Please ask for: Ms Iqraa Malik
Email: iqraa.malik@terraquest.co.uk
Telephone: 01212341390
Our Ref: AW/294/20/HH
Your Ref:
Date: 19th November 2020

Application for Planning Permission for Works or Extension to a Dwelling

Development: 2 storey side extension
Location: 2 Robins Drive Aldwick PO21 3BL

Proposed side elevation
(Remains unchanged)

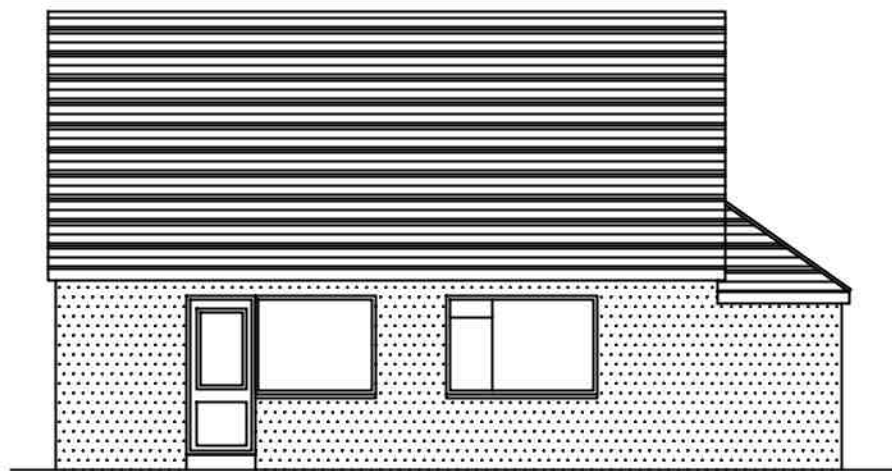
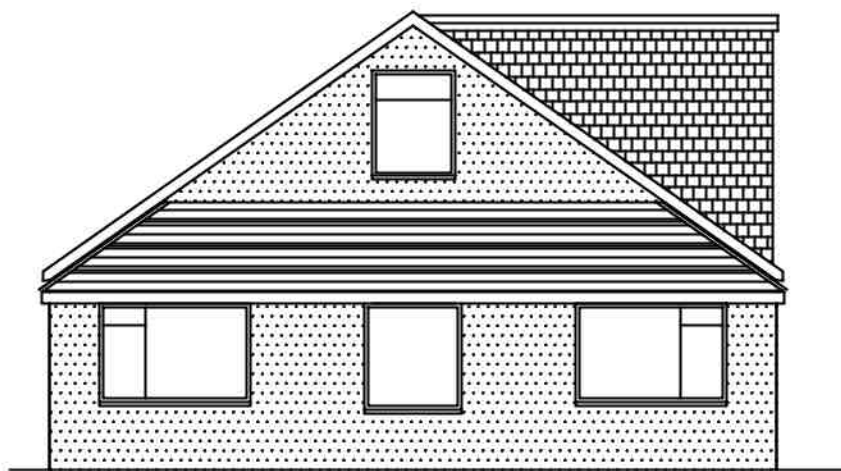
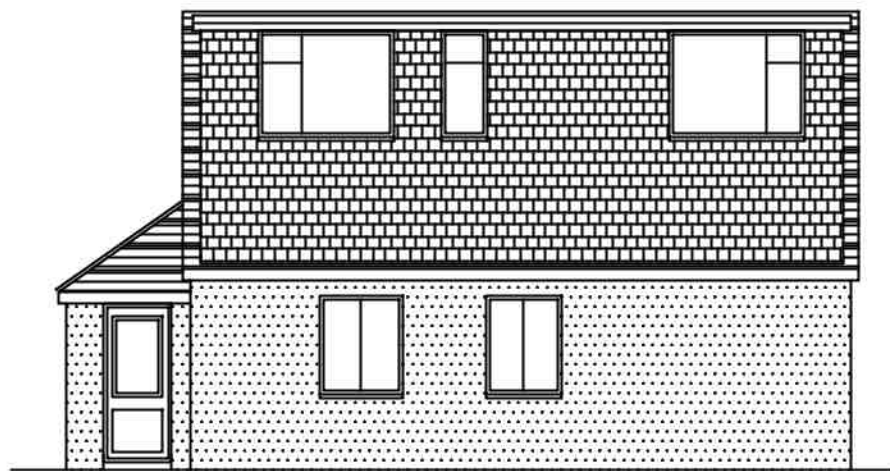
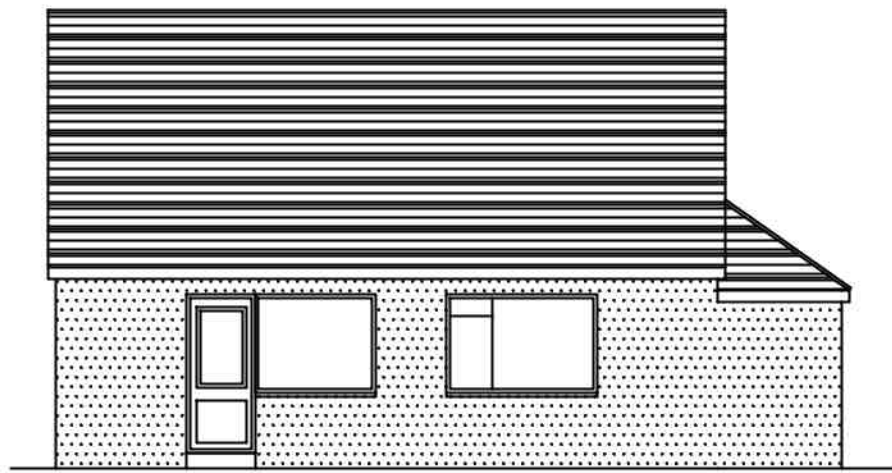
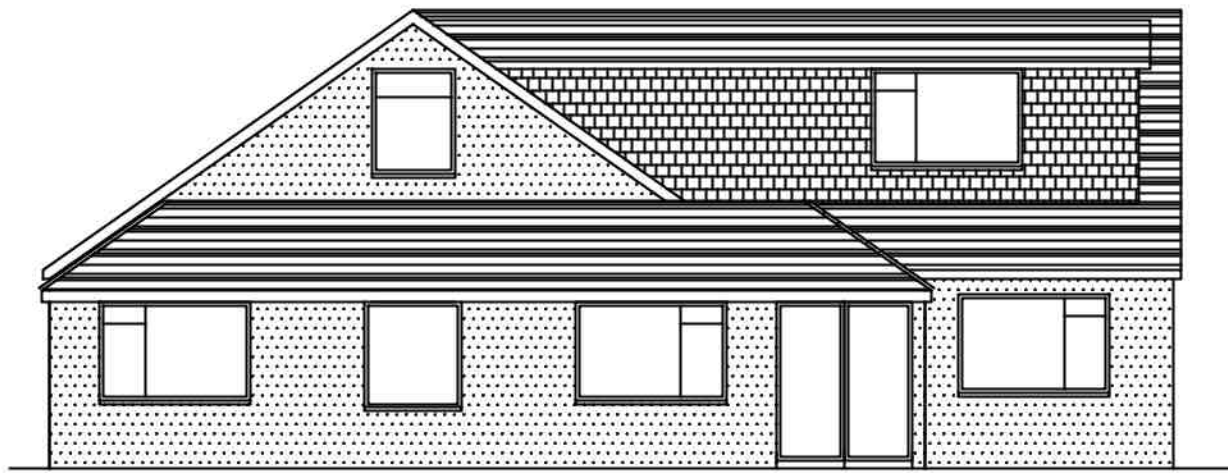
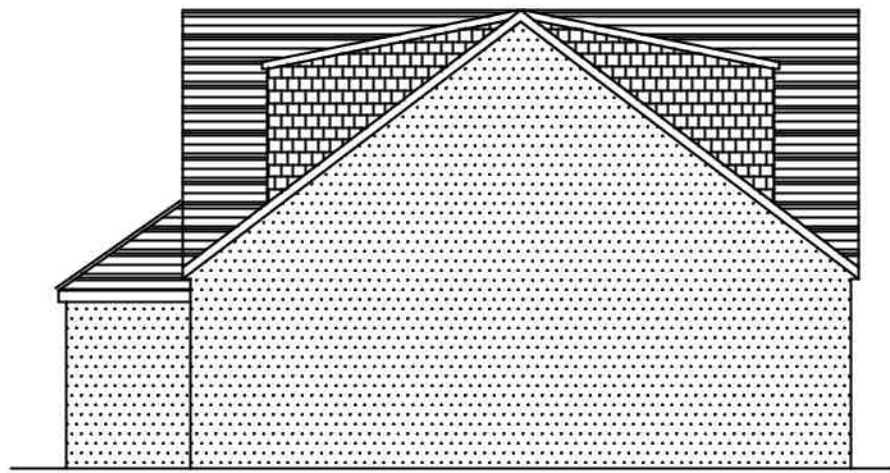
Existing and Proposed Side Elevations

The building line on the existing and proposed side elevation which remain unchanged is inconsistent with the floor plans submitted. Please amend.

Proposed rear elevation

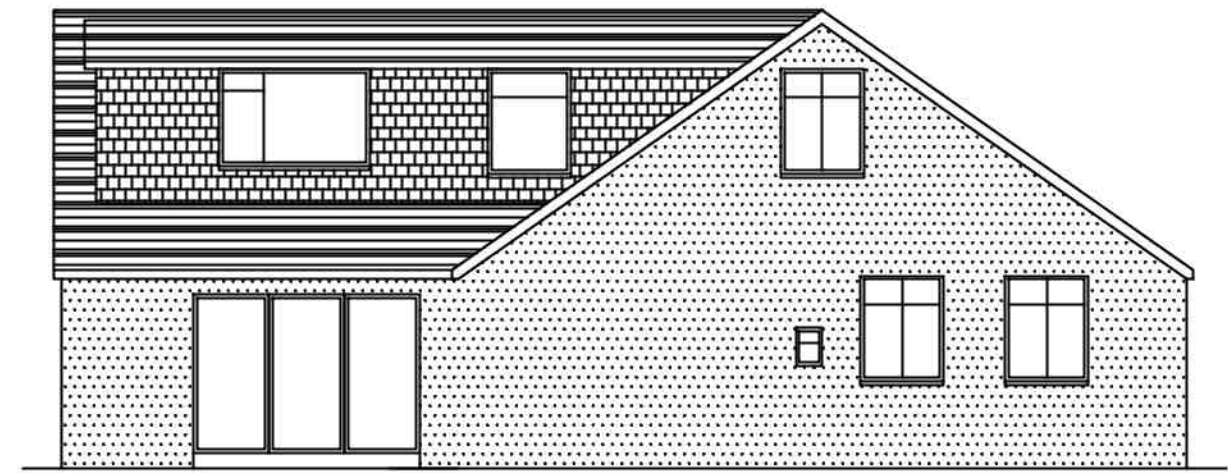
Proposed Rear Elevation

The building line on the proposed rear elevation is inconsistent with the ground floor plan submitted. Along with this, the small window on the rear elevation is missing from the ground floor plan. Please amend.

PROPOSED SITE PLAN - 1 : 500

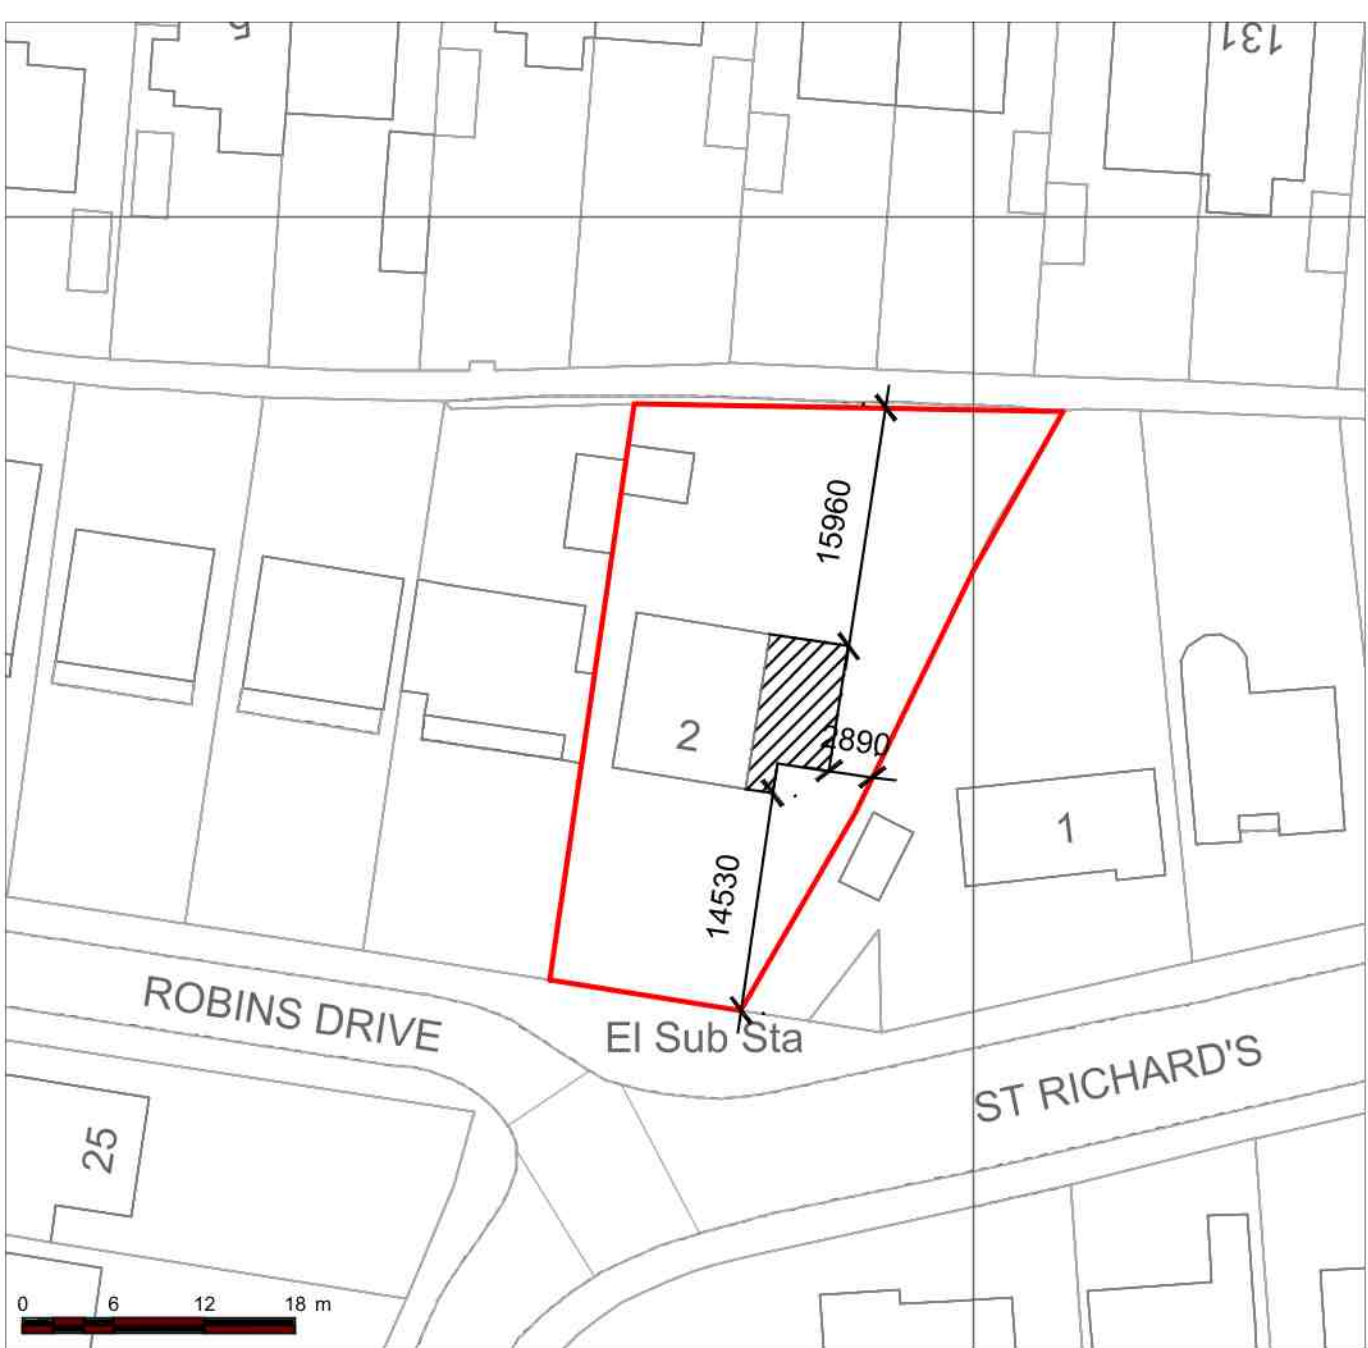
Block Plan

You are required to have dimensions from the proposed extension(s) to all site boundaries. Please amend.
